Planning Officer: Ms M Tomalova

Planning Application Ref: BN/66/19/PL

Location: Land off Canal Mews, Barnham, PO22 0DP

Description of works: Erection of 3 No dwellings

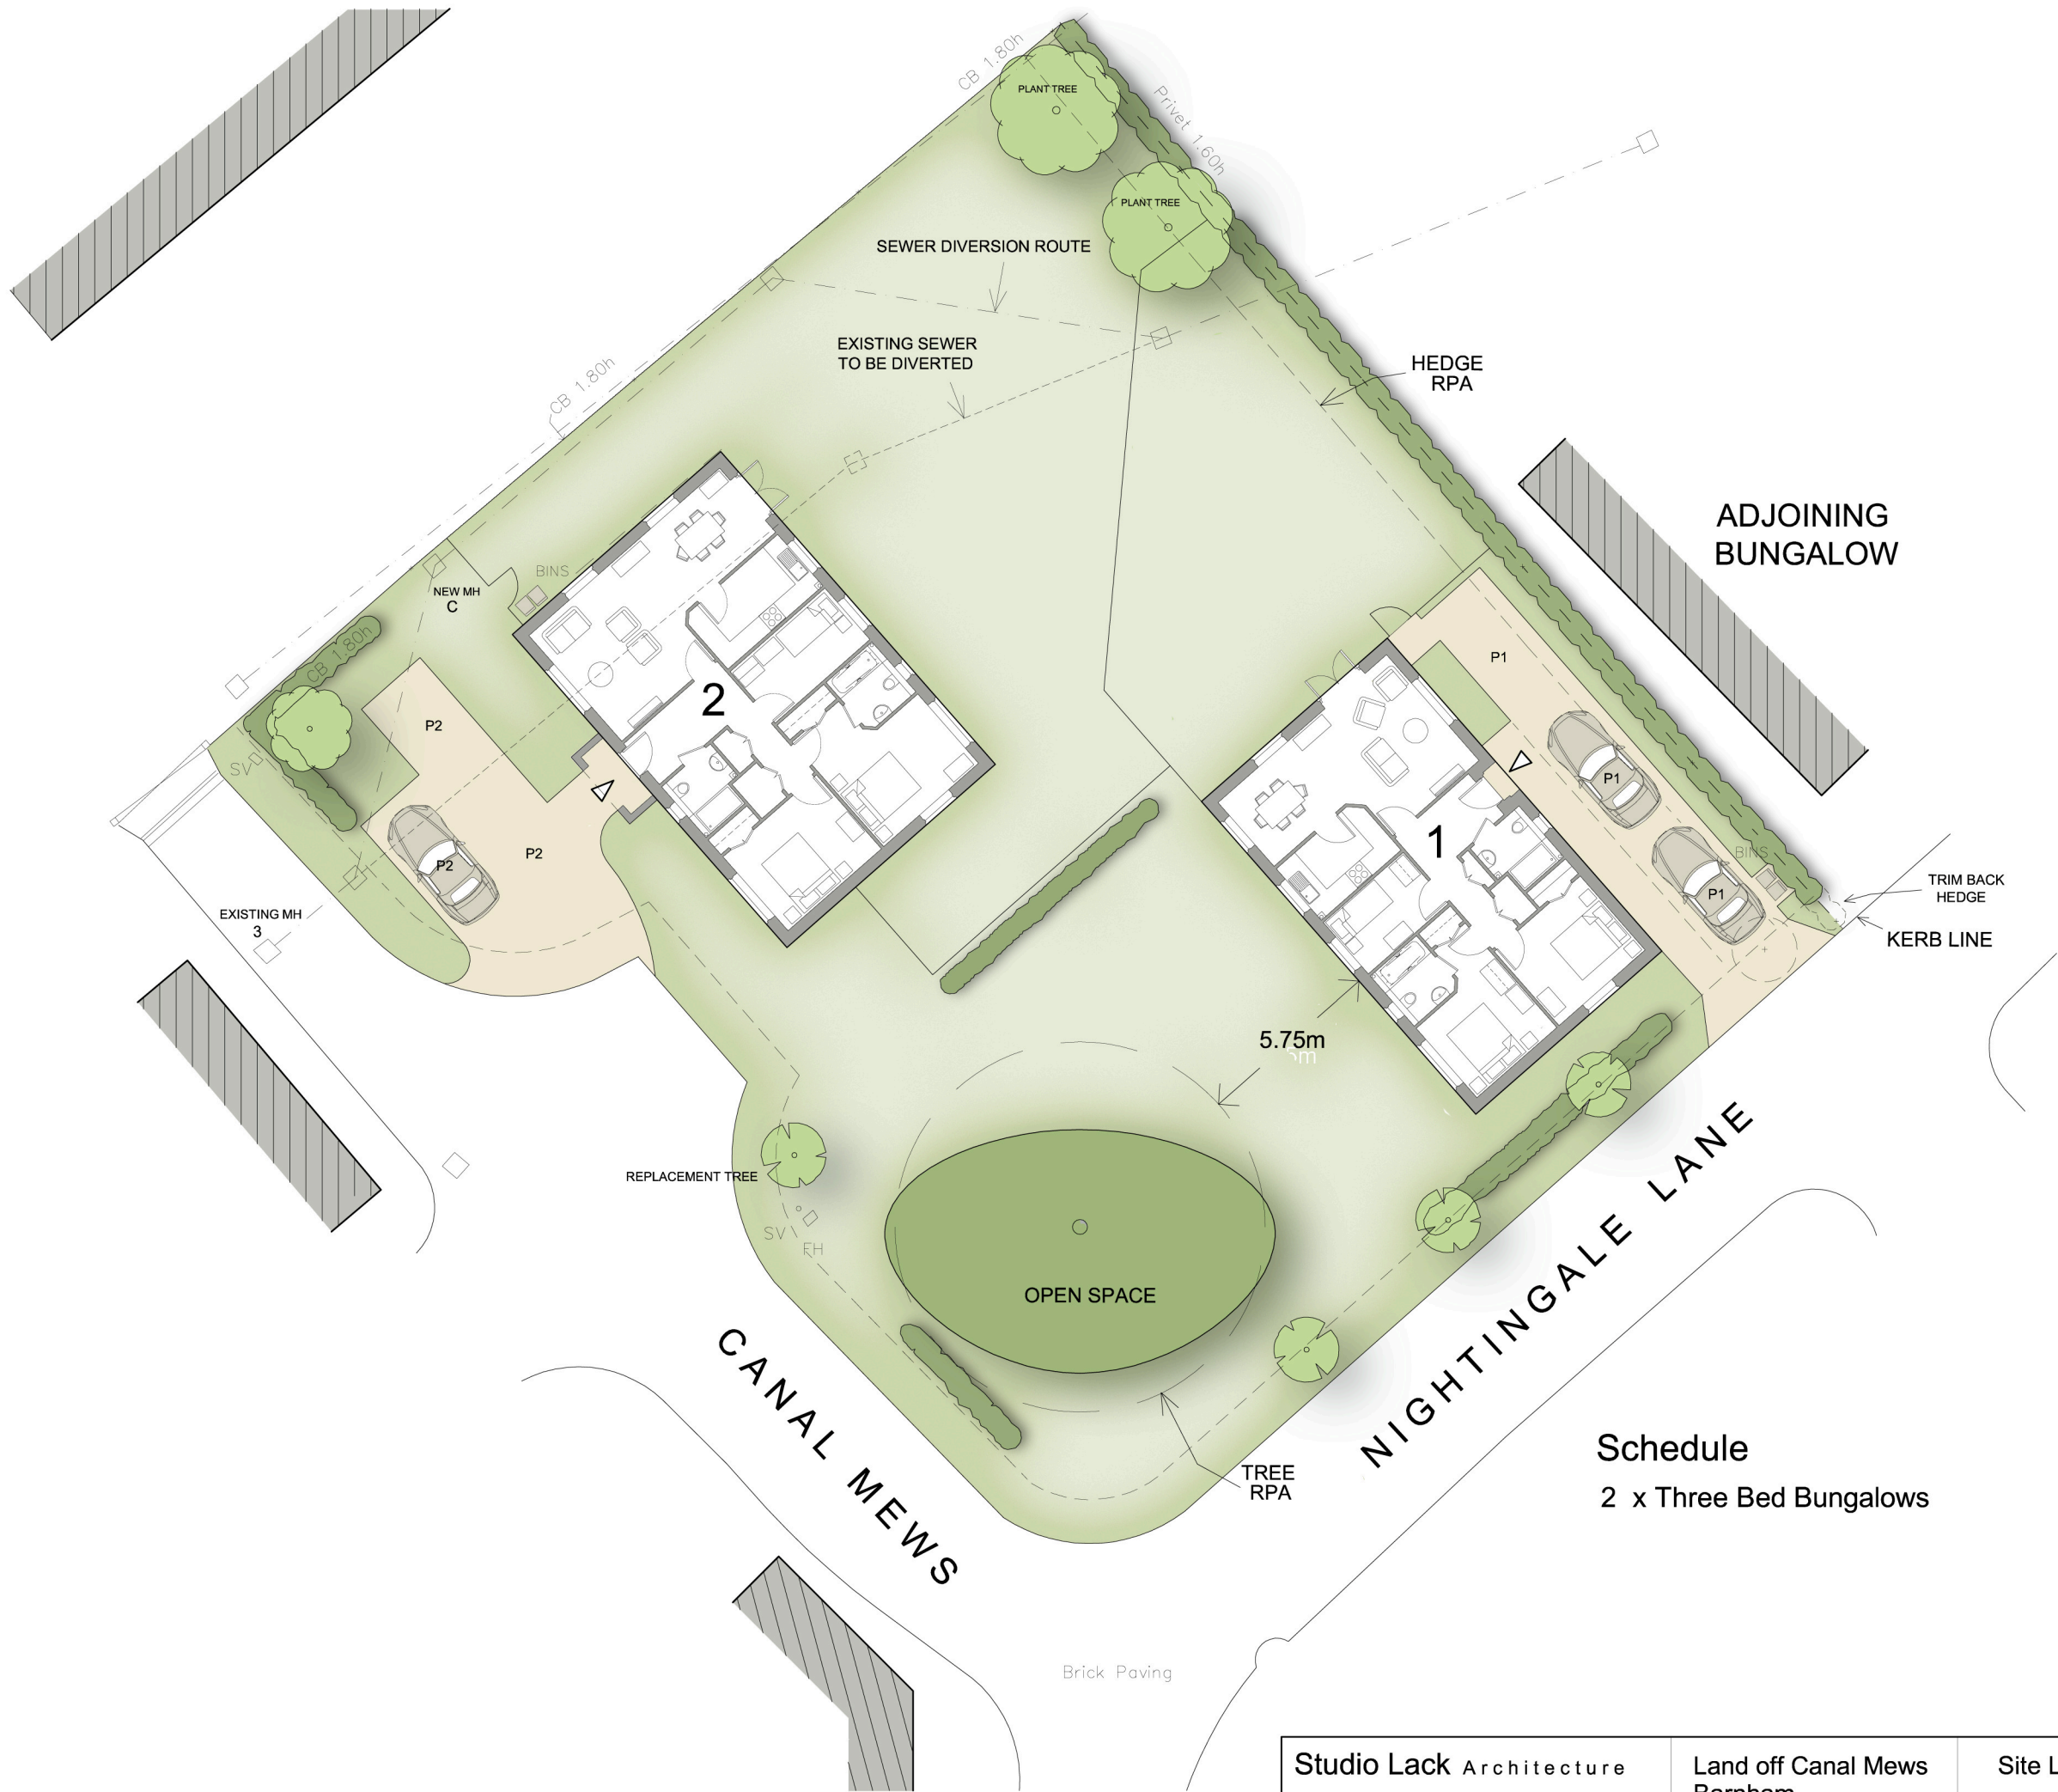
- The applicant has submitted a revised site layout plan, dwg. no. 1705-12. This illustrates avoidance of RPA incursion which is a welcome advance on the previous layout. That said, construction in the form of vehicle parking bays is proposed on two aspects and tight against the RPA perimeter. The practicality of working so close means that were we to approve that layout, some RPA incursion would have to occur. Of greater significance, is the effective containment of the tree by inhibiting future root growth. Both these important areas of conflict have been resolved with the submission of an improved Site Layout plan, dwg. no. 1705-12H

- Plot 1 is going to experience a high level of seasonal nuisance from the presence of (T04 – oak), which will increase if the tree remains healthy and achieves its current potential. Branches will overhang those parking bays and represent a significant nuisance to vehicles (faecal deposits from roosting birds, falling leaves/acorns, dead twigs and small branches) which it can be anticipated will give rise to tree work applications that would be difficult to refuse. Resolved with improved site layout proposal.

Drawing No. 02 - Tree Retention and Protection Plan
Land to the East of Barn Rise, Barnham

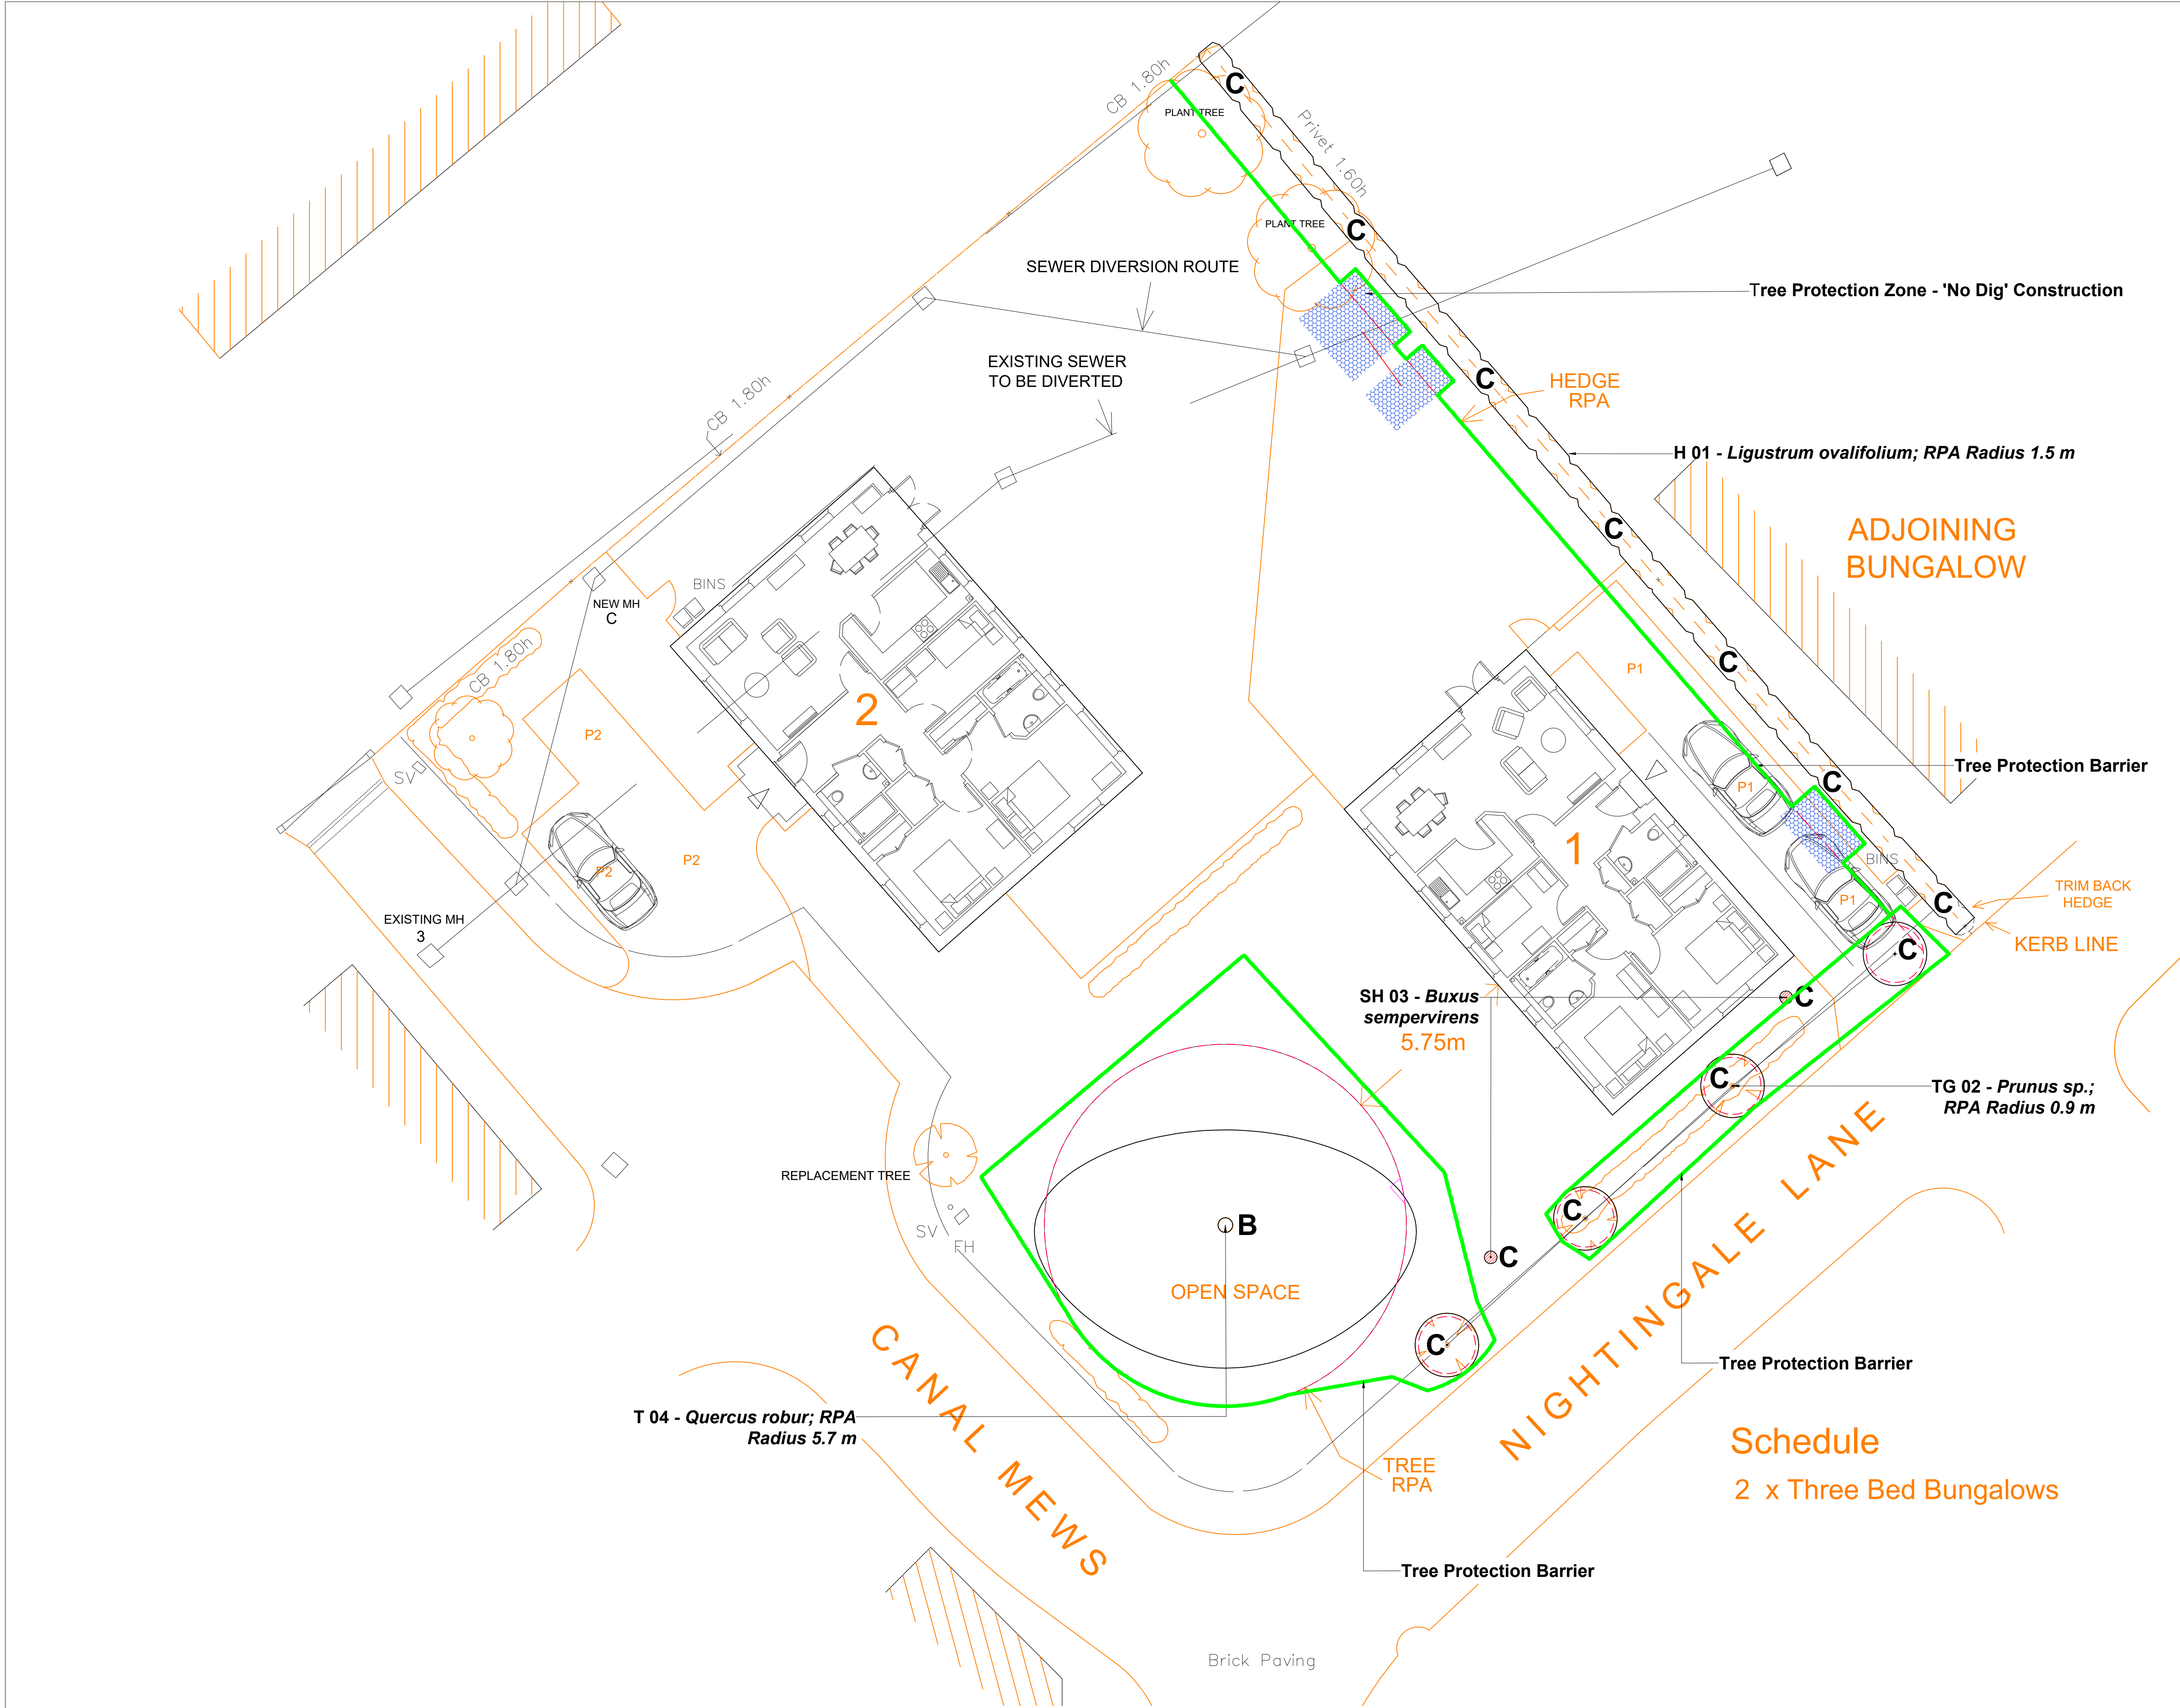
- I recommend this scheme for **APPROVAL**, subject to the following conditions being applied:
 1. Before the site is occupied or any machinery is introduced to the site or demolition work or construction work or alterations to existing ground levels takes place a **PRE-COMMENCEMENT Site Meeting** is to take place between the Planning Authority's Tree Officer and the Arboricultural Expert representing the site owner(s) – at this meeting all protective fencing will be inspected to verify it is 'Fit for Purpose' as required under British Standard 5837:2012 and have been erected and positioned exactly as shown on the **Tree Retention Protection Plan, dwg.LLD1345-ARB-DWG-002, Rev 02**.
